KITITIAS COUNTY

MEMORANDUM

TO: Community Development Services
FROM: Public Works Planning Review Team
DATE: September 23, 2020
SUBJECT: CU-20-00003 Carey Mini Storage

# Site Plan

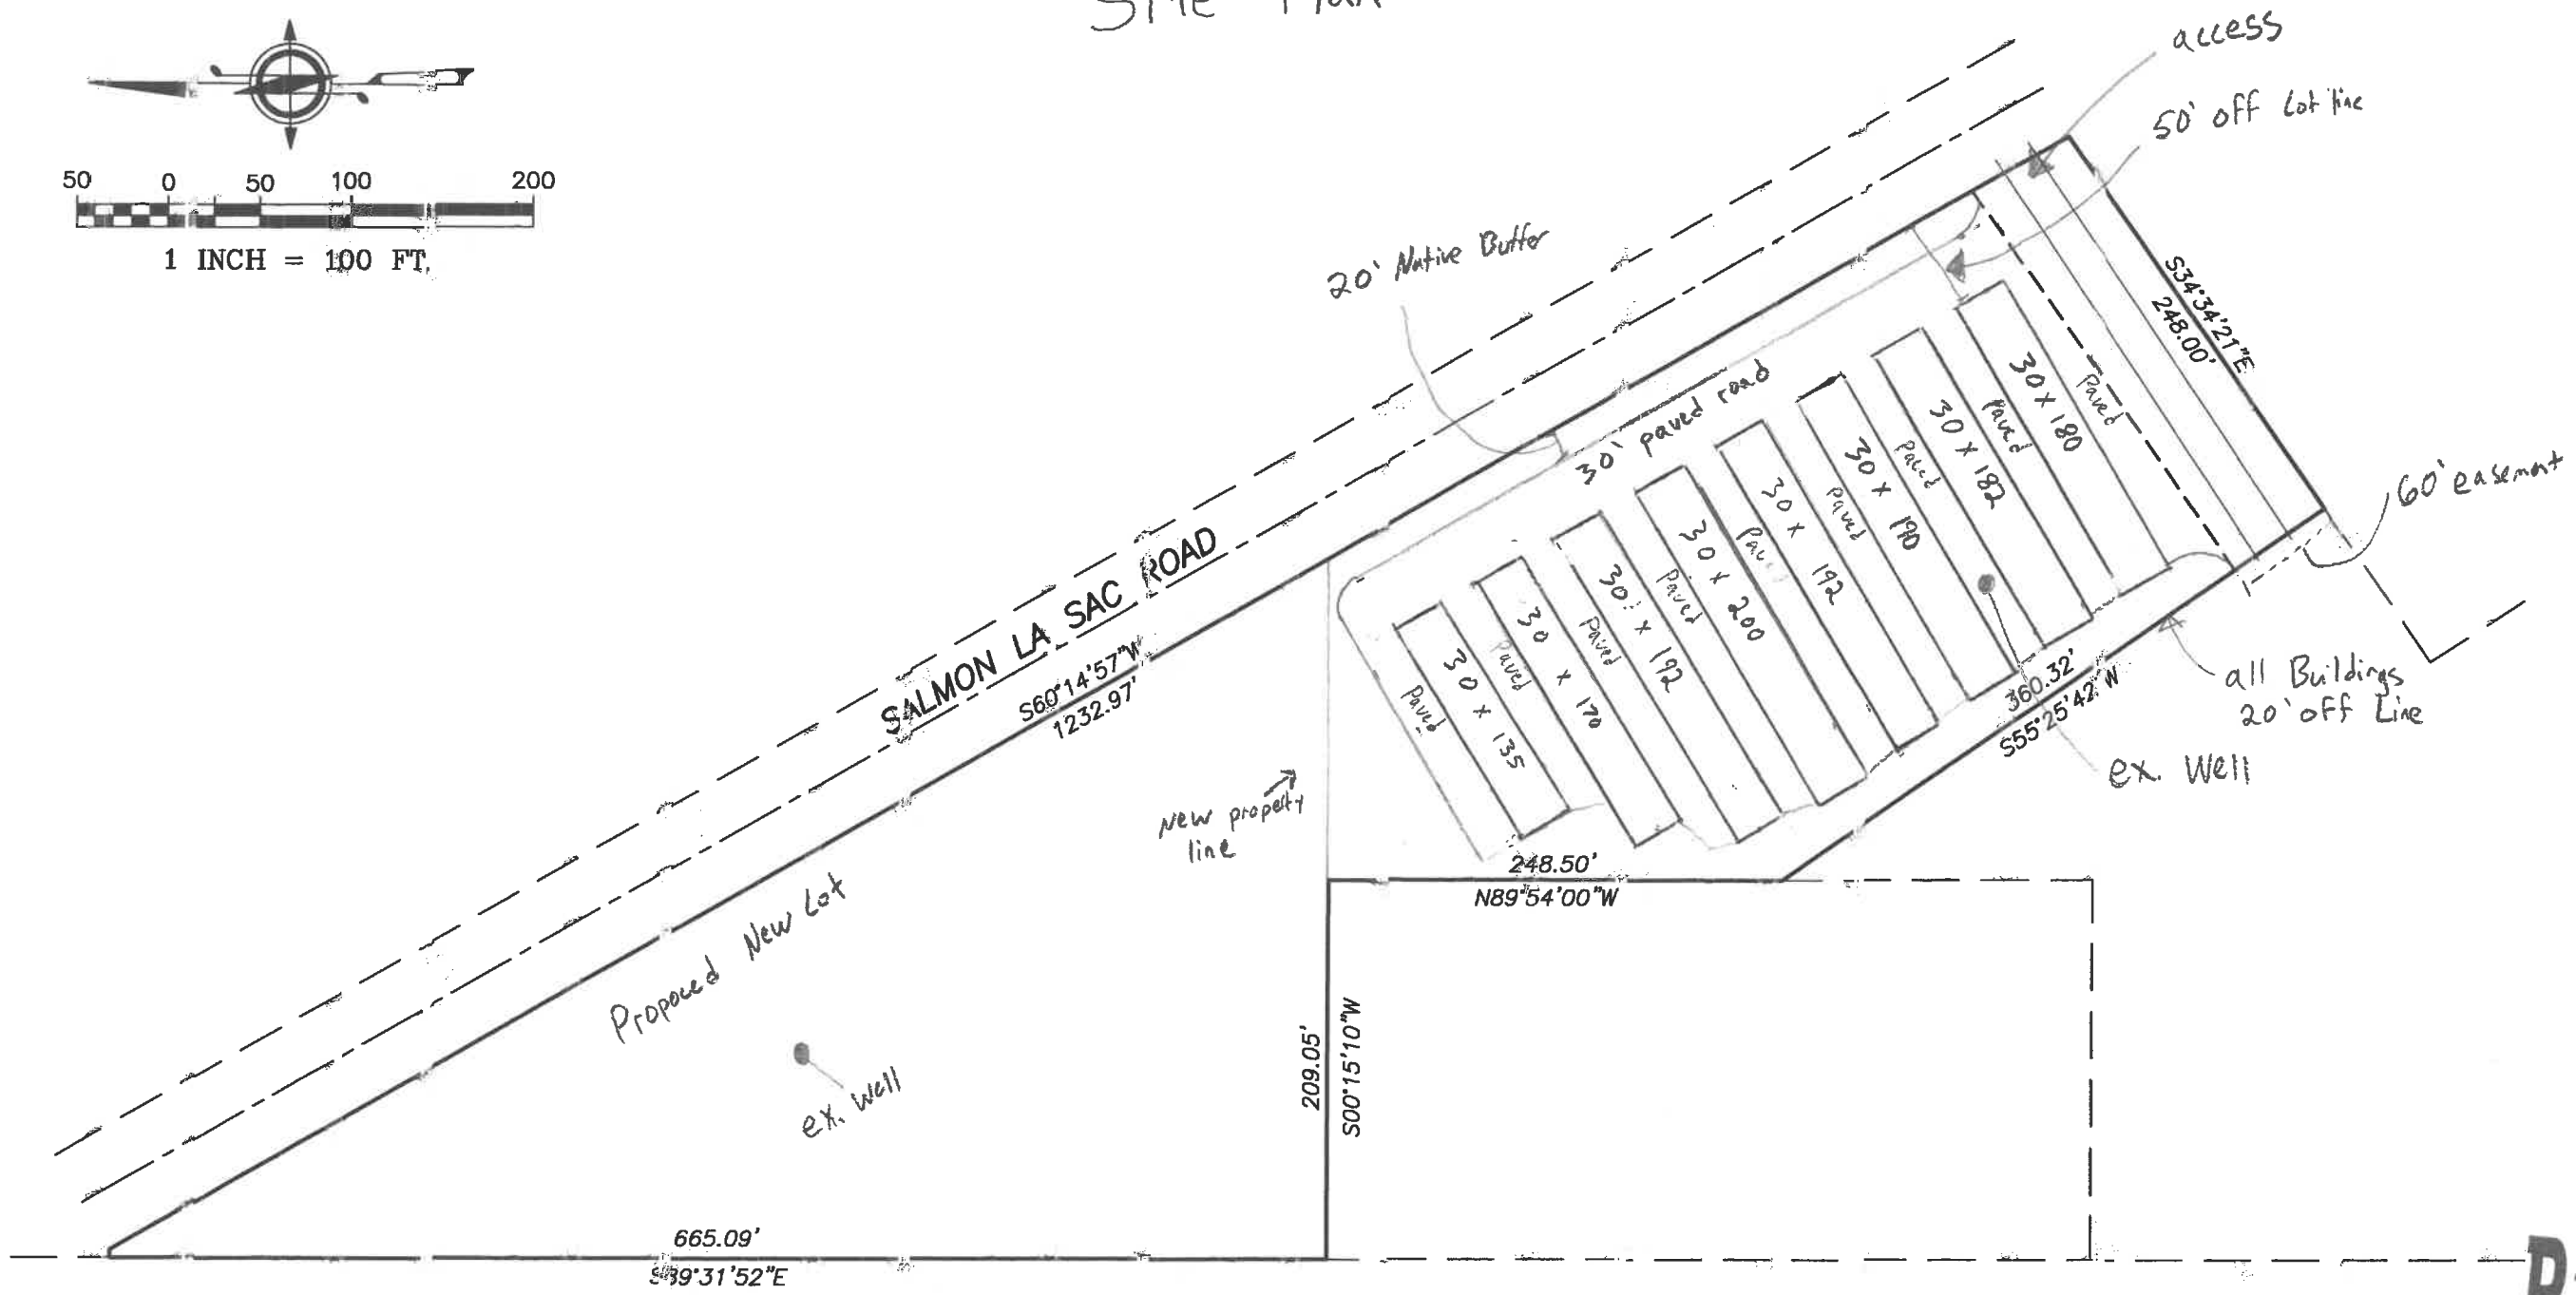
- A. Access permit required: The Carey Mini Storage will require an access permit for a commercial entrance.
- B. Proof of Access: Salmon La Sac is a Federal roadway. Proof of access is required.
- C. Grading Permit: A grading permit is required for any dirt work exceeding 100 cubic yards of excavation and/or fill.
- D. Stormwater Plan: Engineered Stormwater plans are required in compliance with the Eastern Washington Storm Water Manual.
- E. Transportation Concurrency: A transportation impact analysis (TIA) shall be required for all development that will generate more than nine (9) peak hour vehicle trips unless the requirement for a study has been waived by the Public Works Director.
